Application no: H13-0351-15

Description: Erection of 2 detached dwellings and pair of semi-detached dwellings

Location: Site Adjacent: 37 Woodgate Road
Moulton Chapel
Spalding
PE12 0XF

Amendment: Alteration to landscaping (dwg. no. 15/404/PA/005A)

Drawing No.
15/404/PA/005A

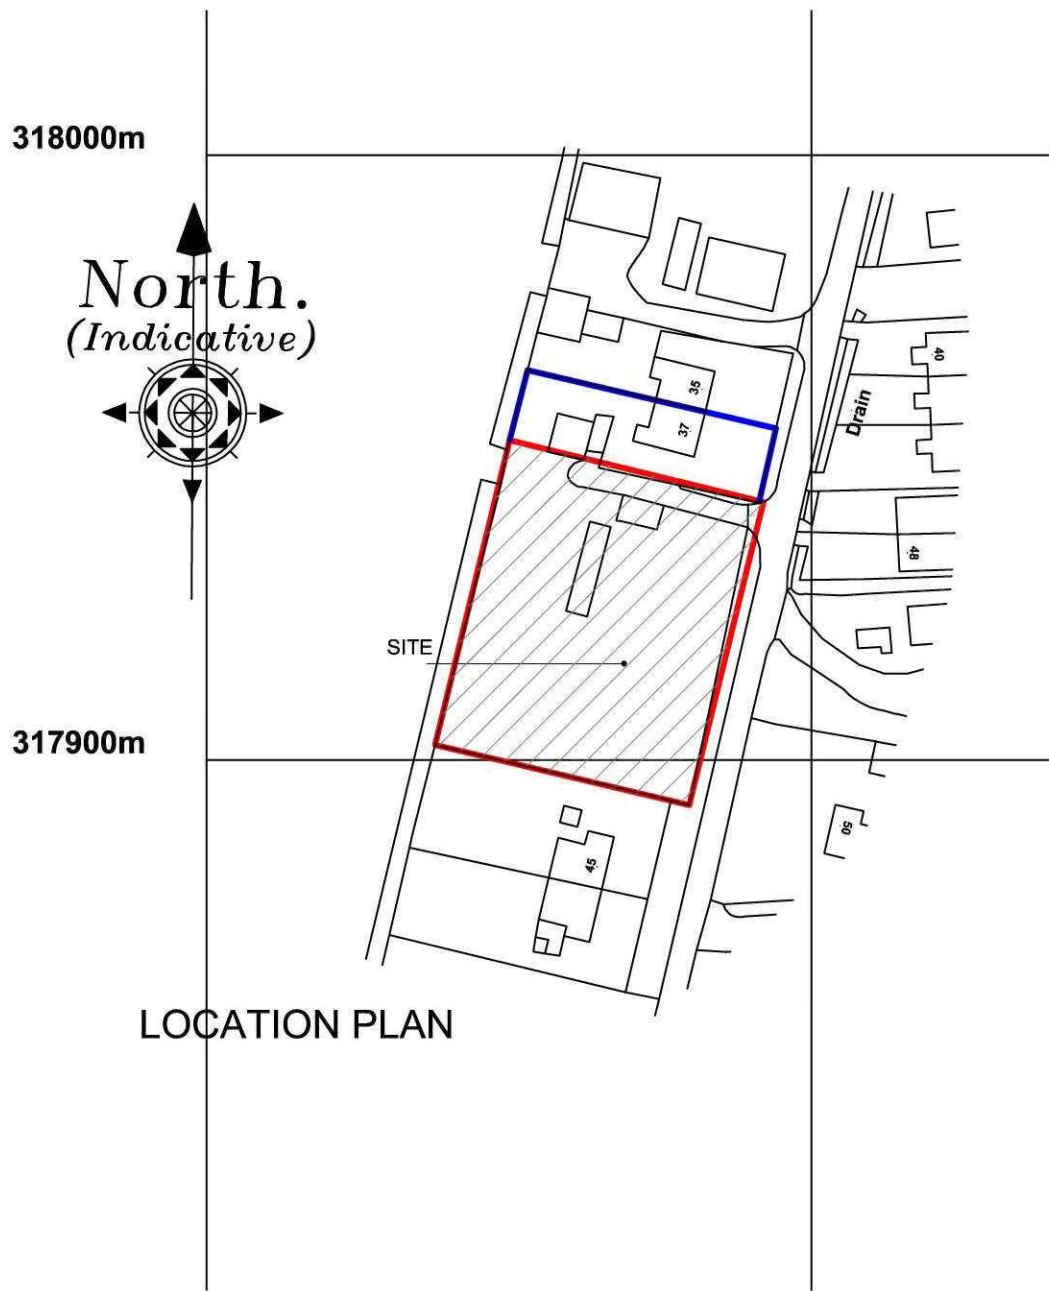
It is considered that the frontage layout is rather urban in appearance and should be softened. This could be achieved by a reduction in the size of the driveways and additional tree planting. The latter should include the retention of existing native trees fronting the site, as far as possible, if they are worthy of retention. The existing Leylandii hedge might as well be removed in its entirety and replaced by native hedging (eg, Hawthorn).
